Case Officer: Linda Griffiths

Proposal: Partial Discharge of Conditions 8 (proposed site and floor levels), 11 (drainage scheme), 25 (street lighting) and 32 (trees or hedgerows) of 14/01932/OUT relating to the new Bloxham Road Access

DATE: 16 March 2021

Drawing Title: **S278 WORKS DRAINAGE CONSTRUCTION DETAILS SHEET 2 OF 2**

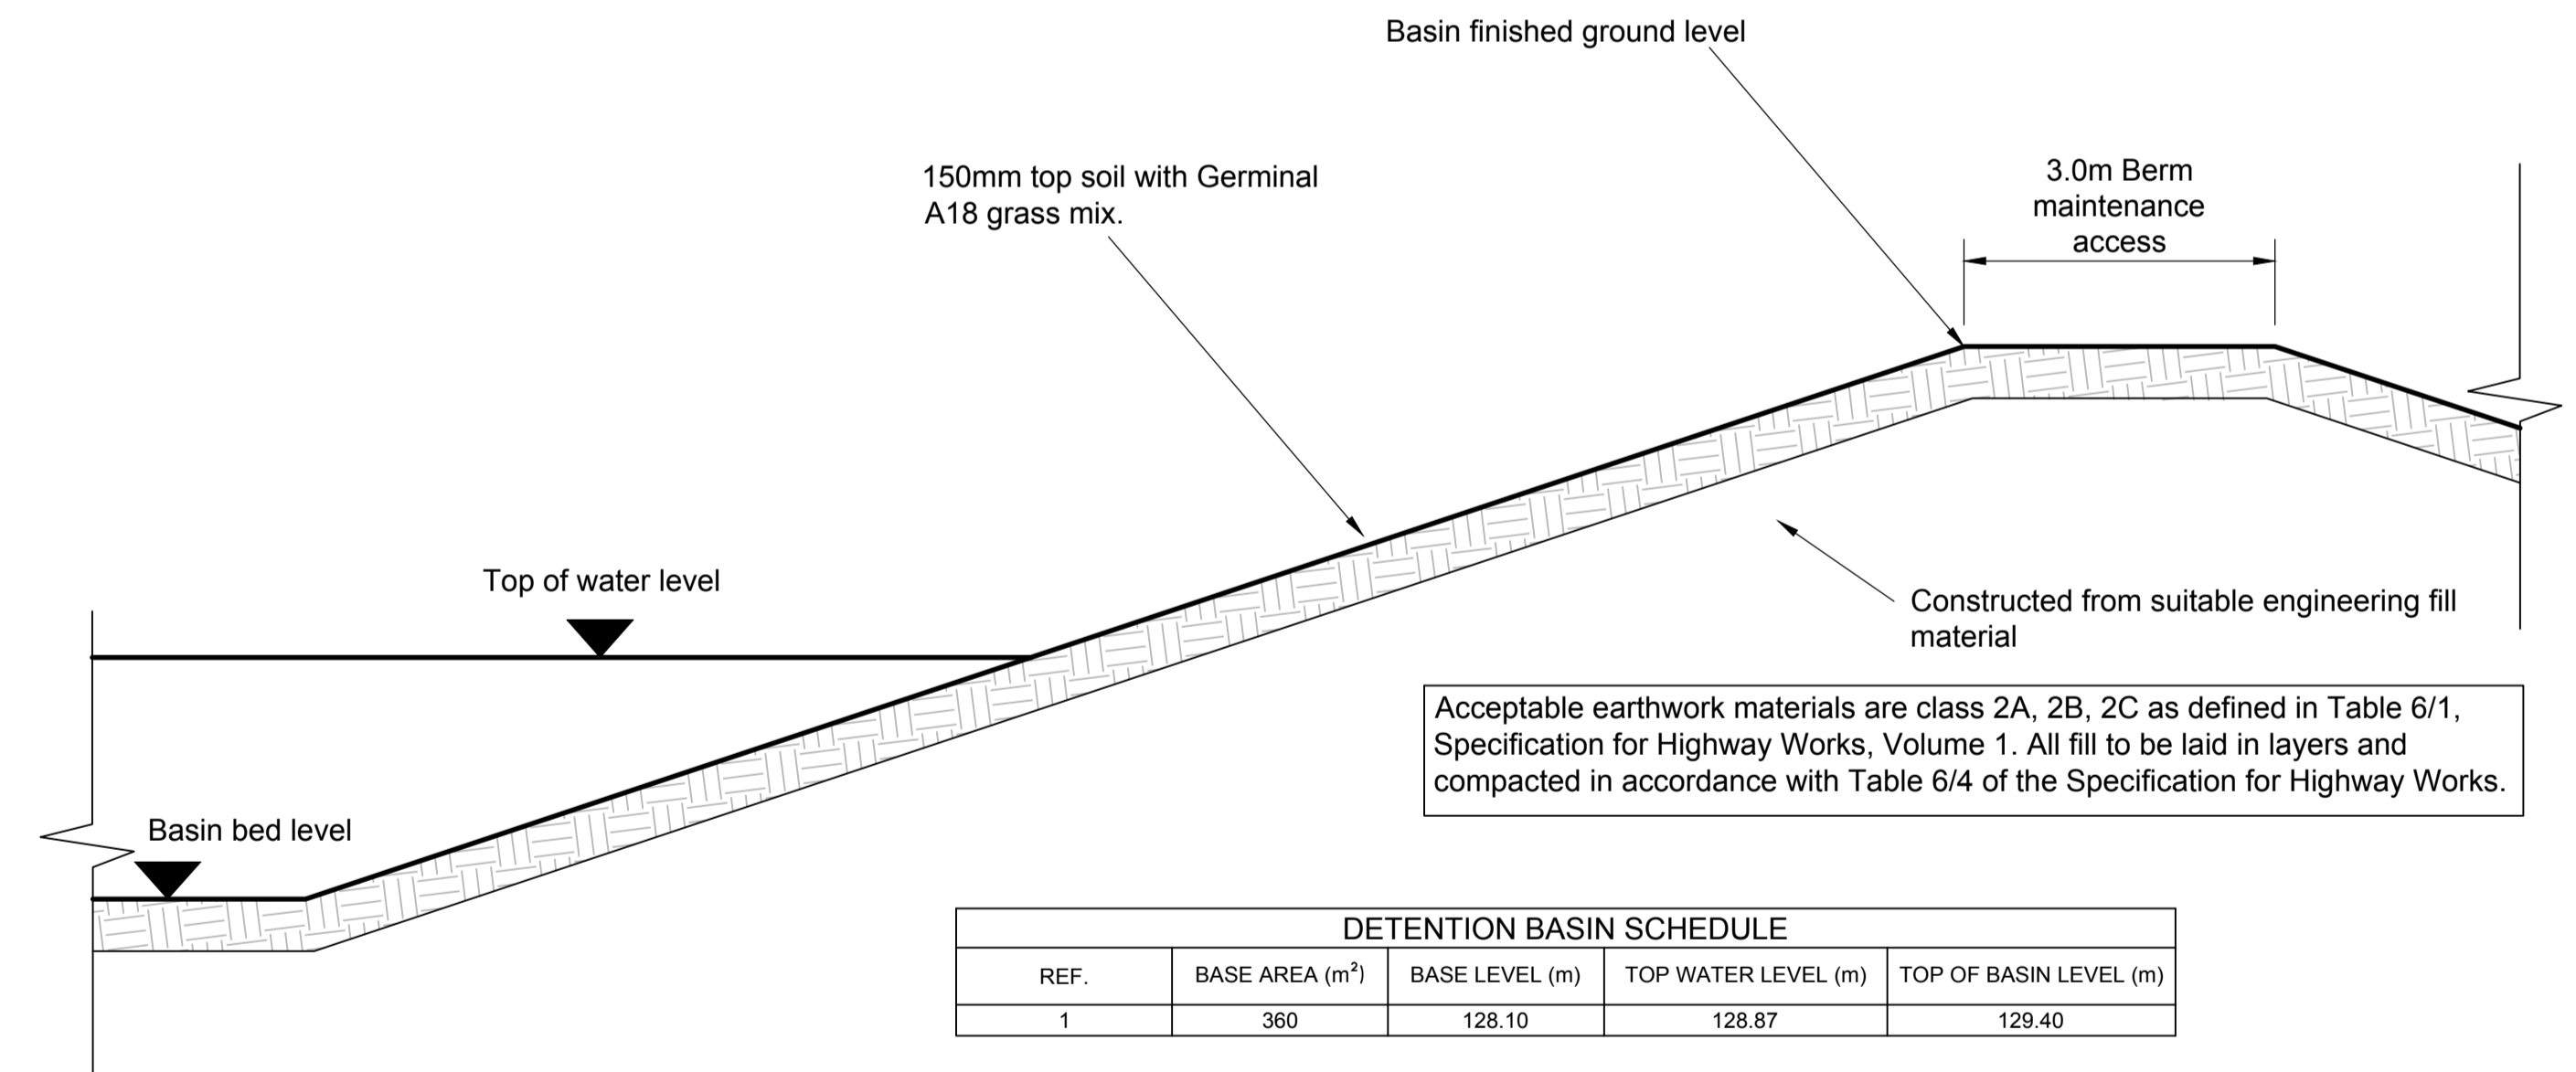
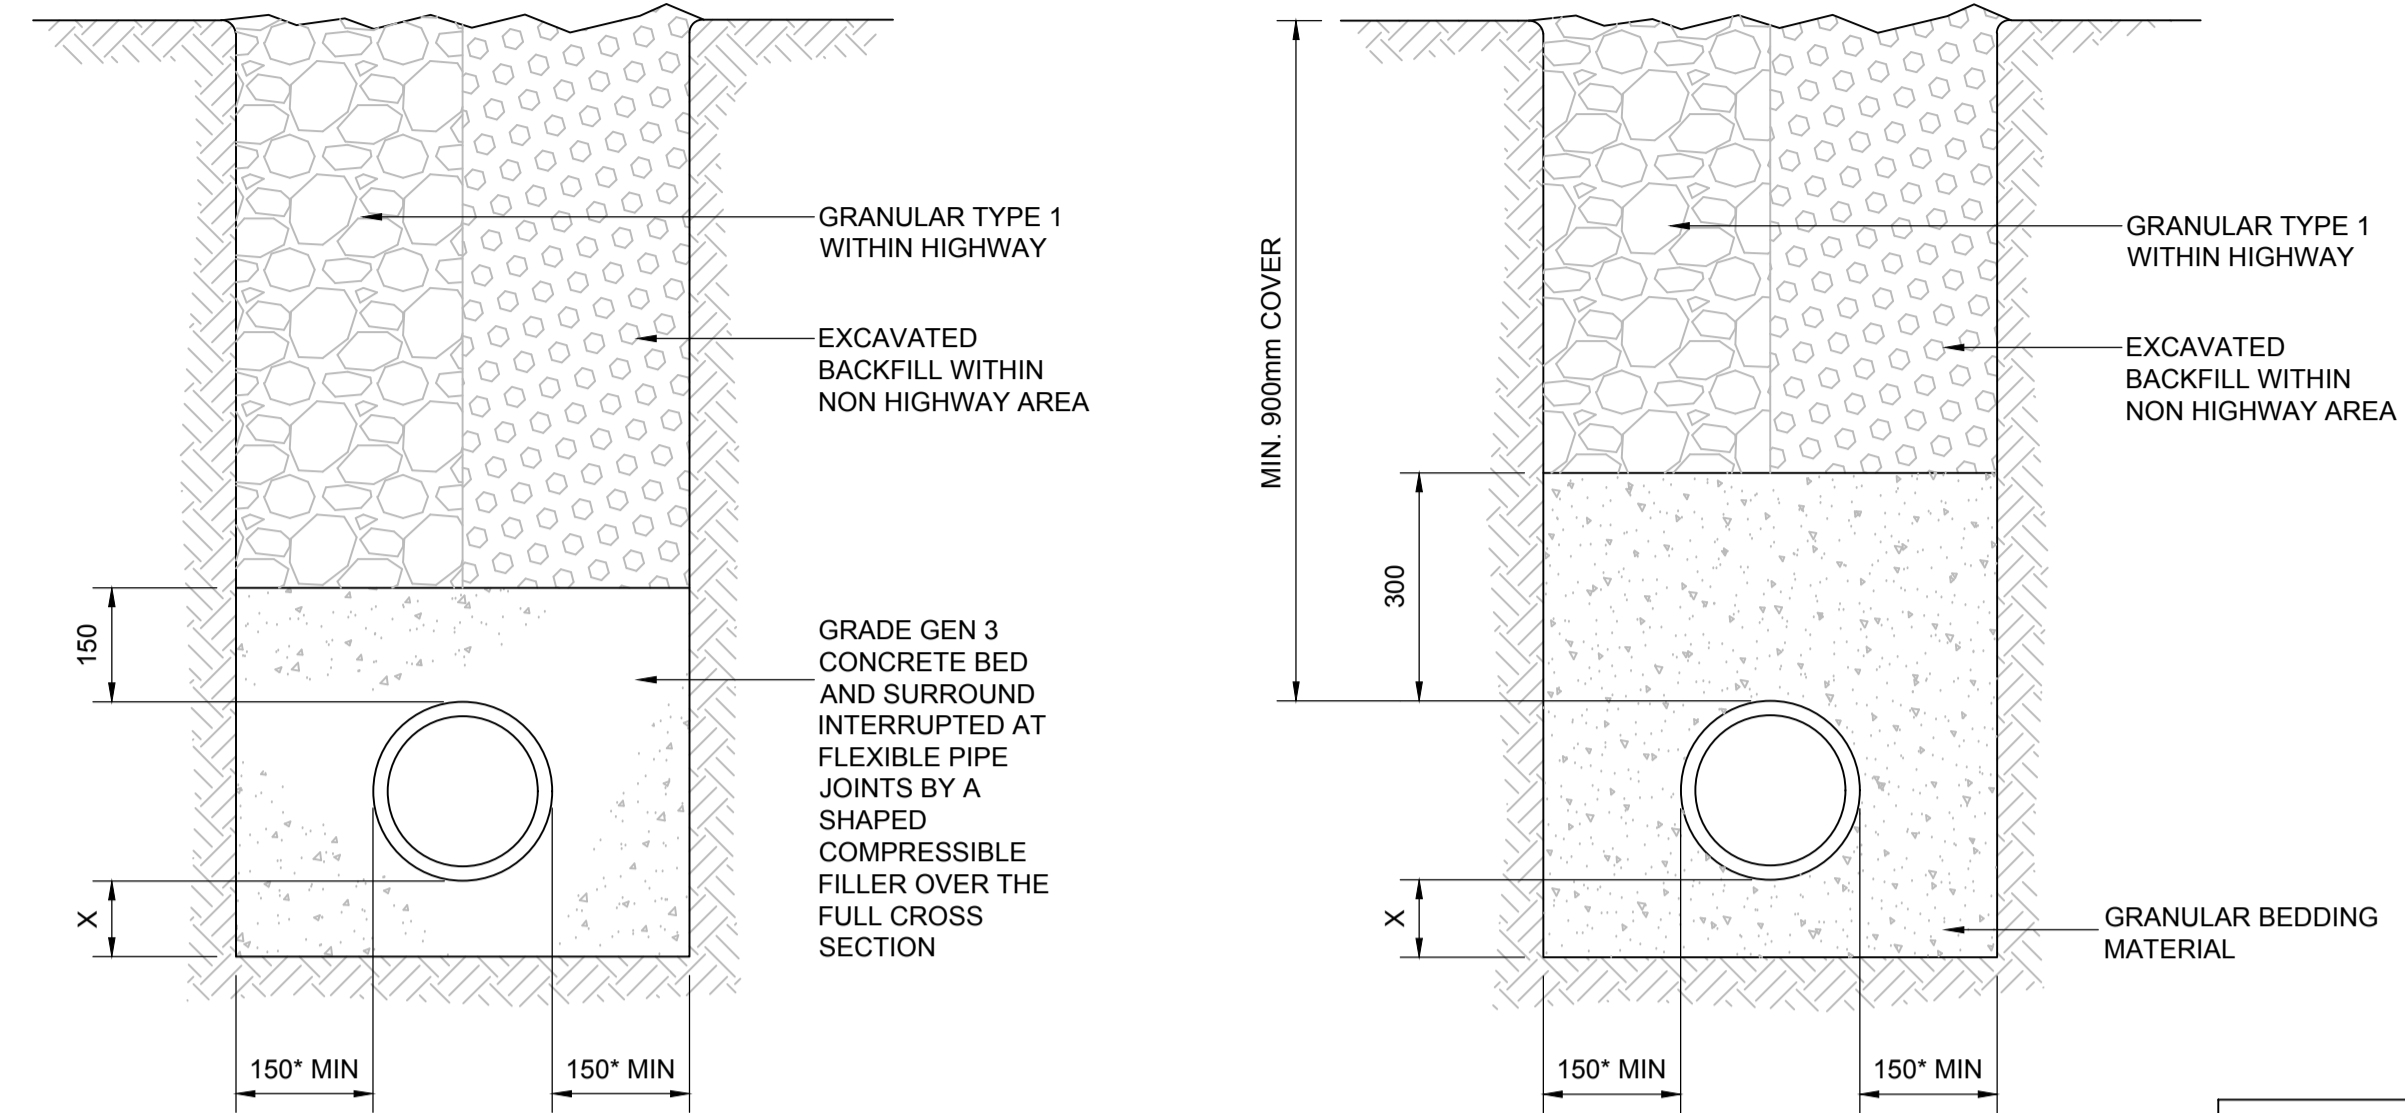
4.2 CDC Landscape Officer: concerns about depth of attenuation basin which has no overflow and no construction detail for the headwall into the basin.

- 5.2 Condition 11 – relates to the drainage details. As above, these have been assessed by OCC and the drawings are included in the S278 Technical Audit Certificate. CDC Landscape raised a concern regarding the depth of the attenuation basin and the lack of detail for the headwall into the basin. As OCC have raised no objection and the drawings have already been technically approved under S278, it is considered that the proposals are acceptable.
